CITY OF ALBUQUERQUE

July 3, 2013

**Re: Lot 12, Block 1, Unit 2, Chamisa Ridge Grading and Drainage Plan,
6216 Wild Onion Ave. NW, Engineer's Stamp dated 06-05-2013 (B-10/D002B)**

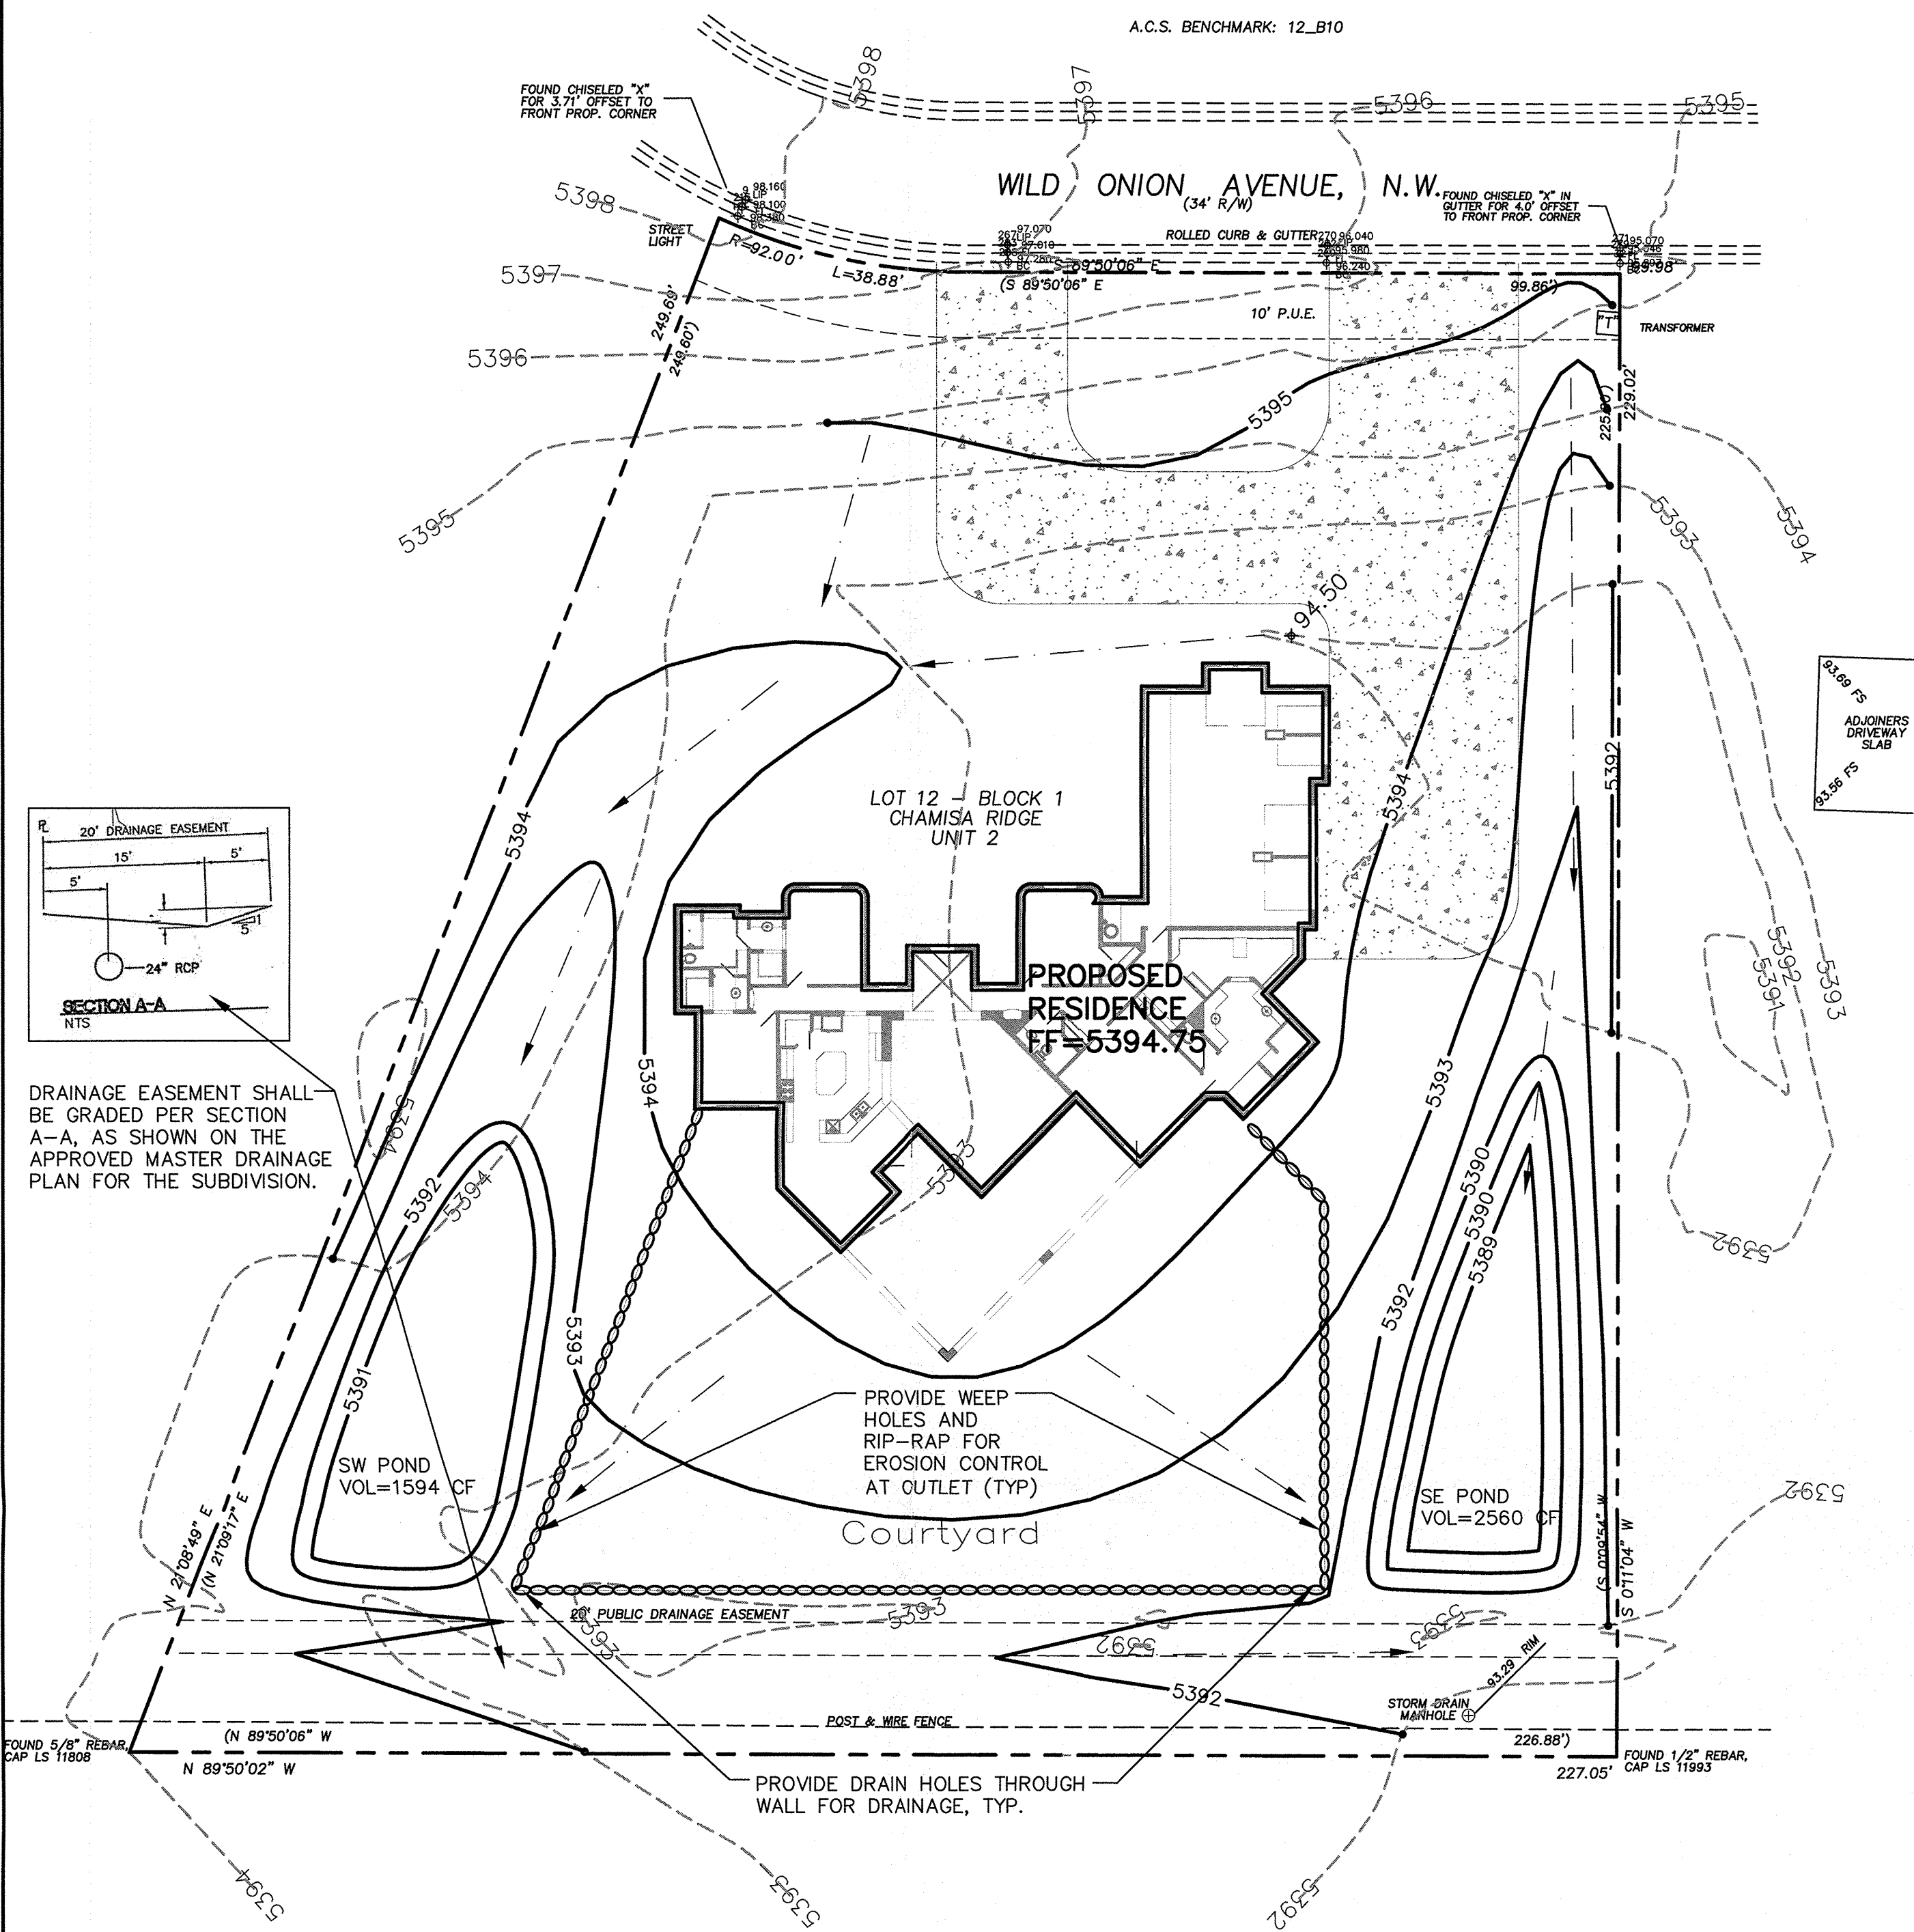
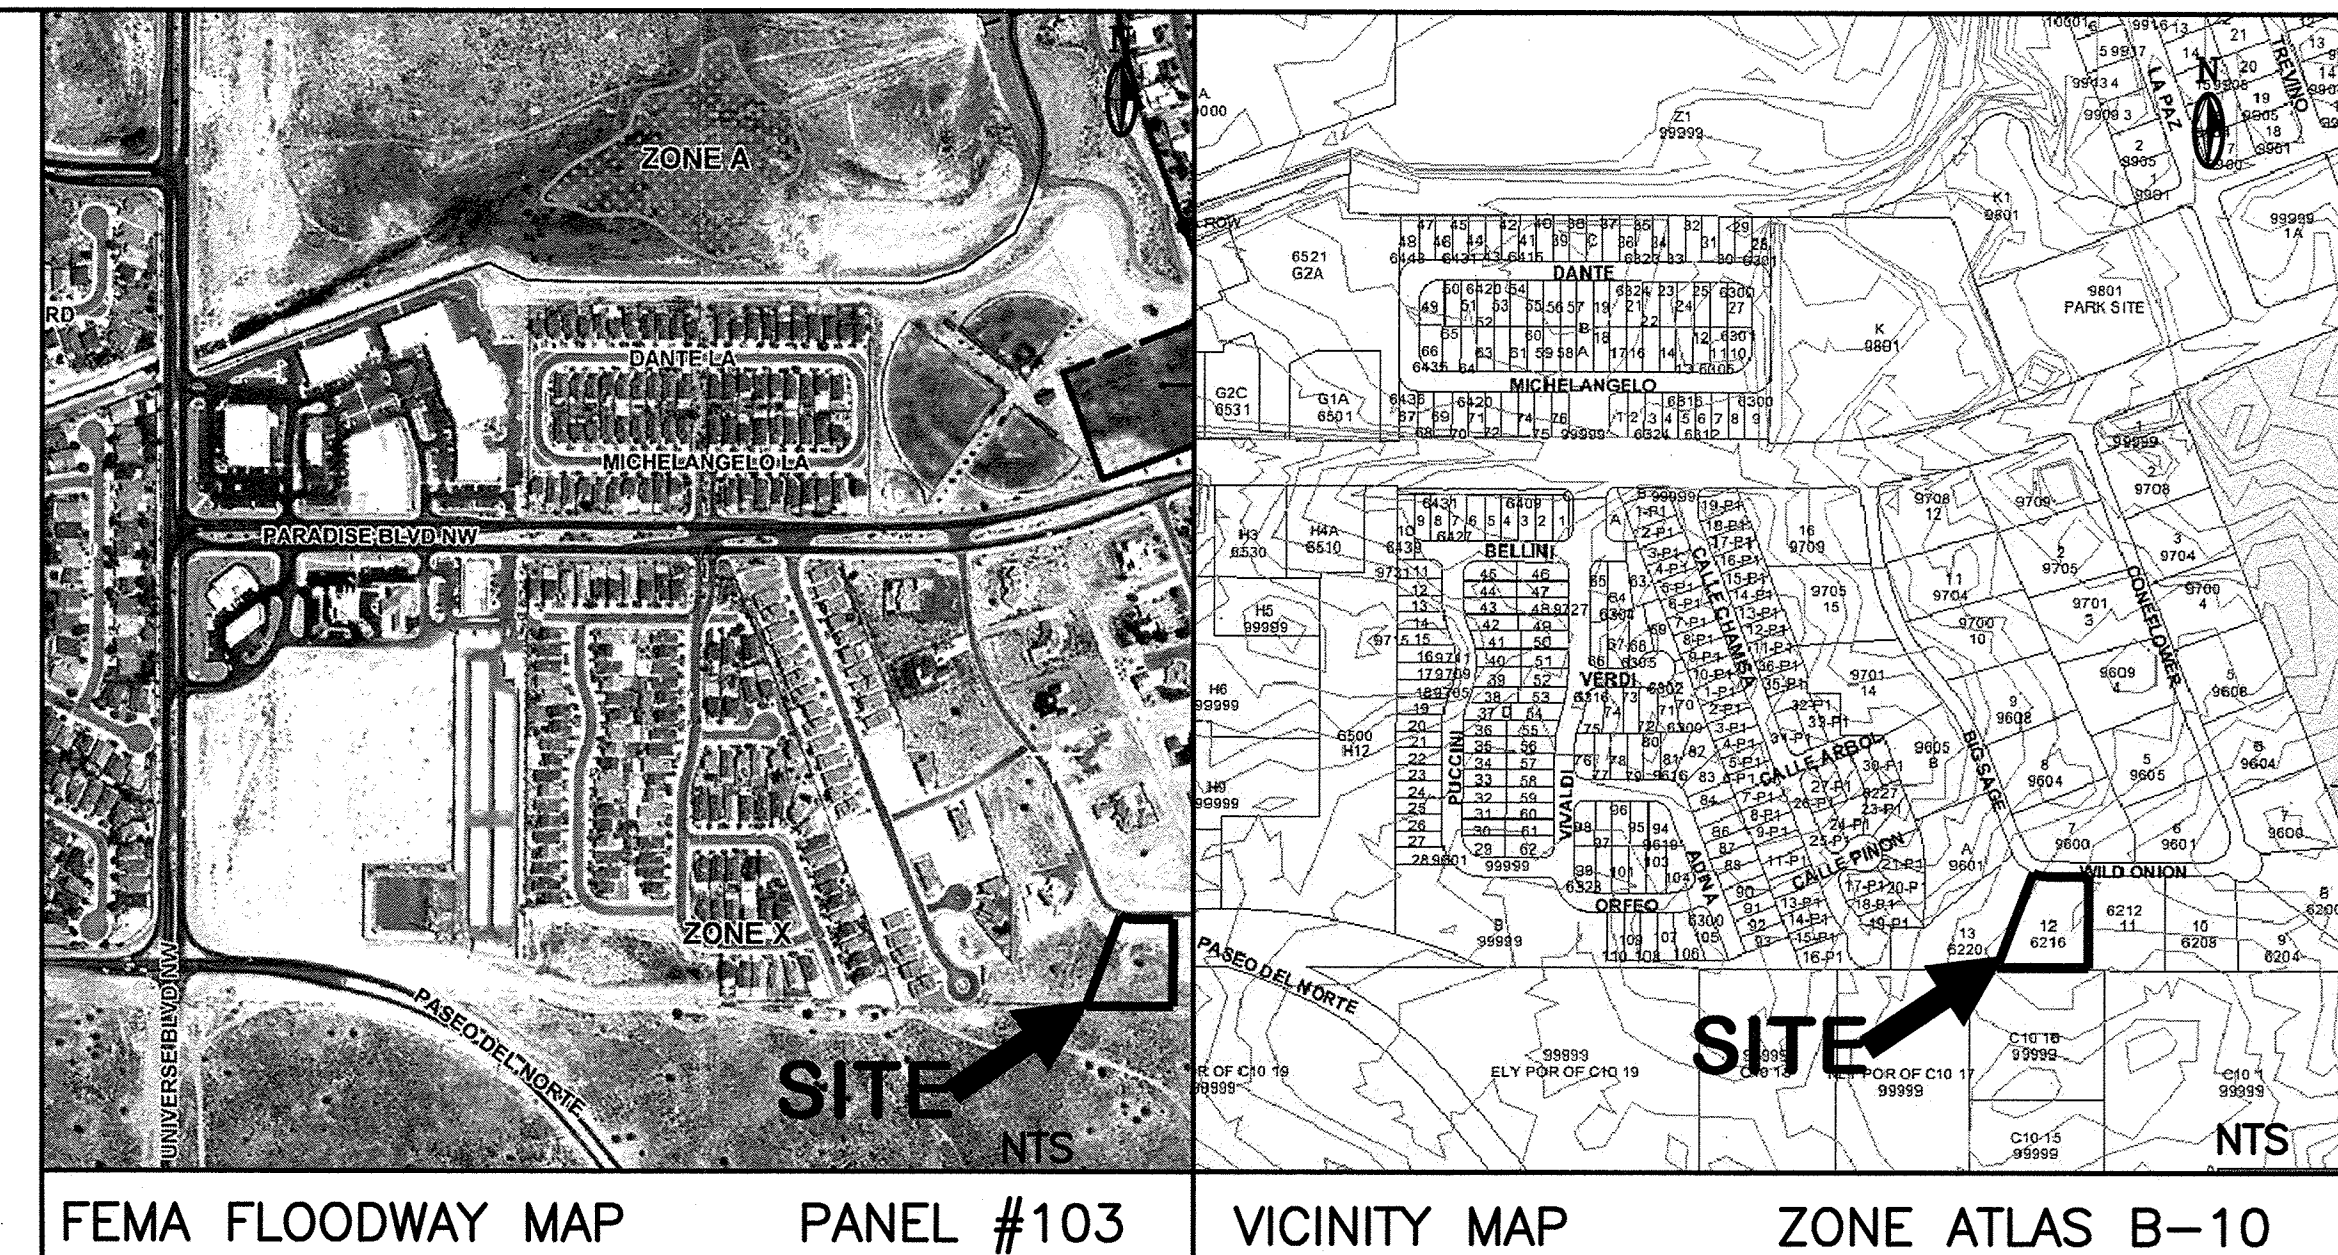
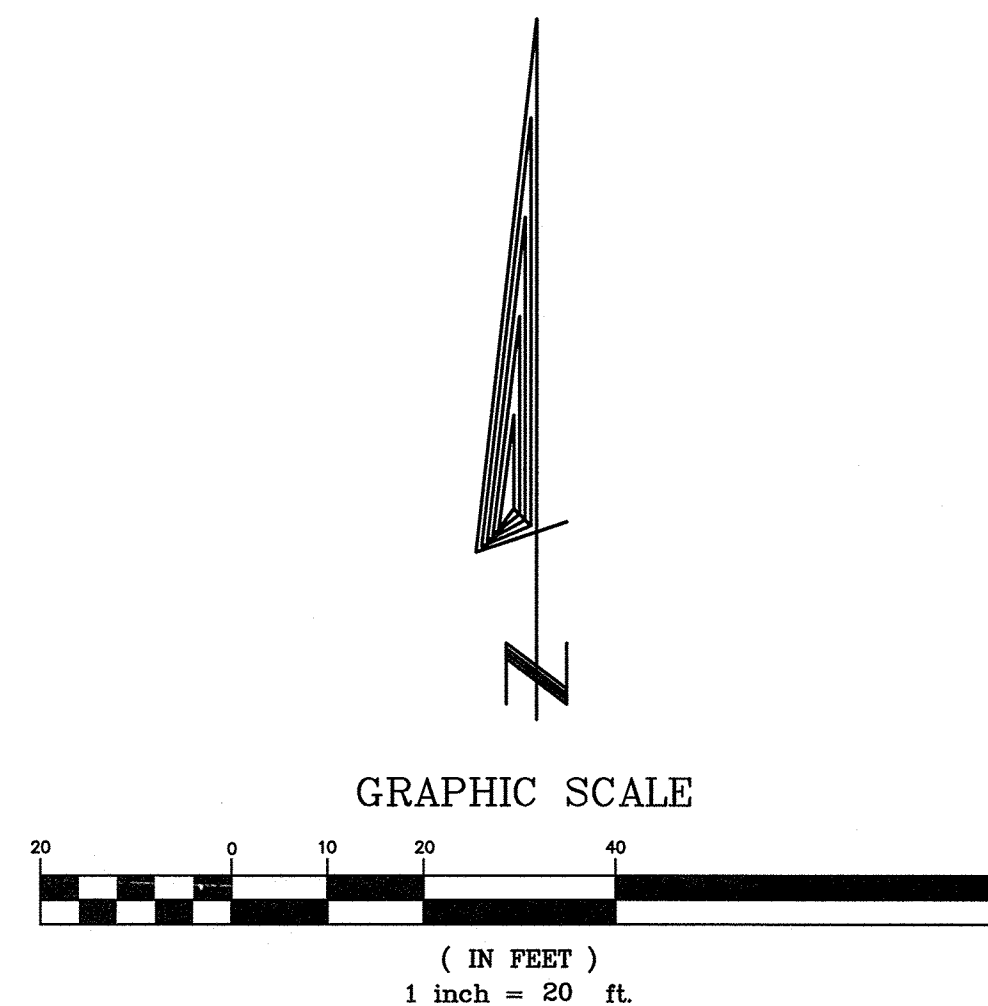
- Confirm that the developed runoff from the proposed building is able to be fully conveyed downstream to the detention pond through the existing drainage easement.
- Provide flowline elevations along Wild Onion Ave. to ensure an adequate waterblock is created.
- Label all proposed contours and enlarge the font on existing contours to make them more legible.
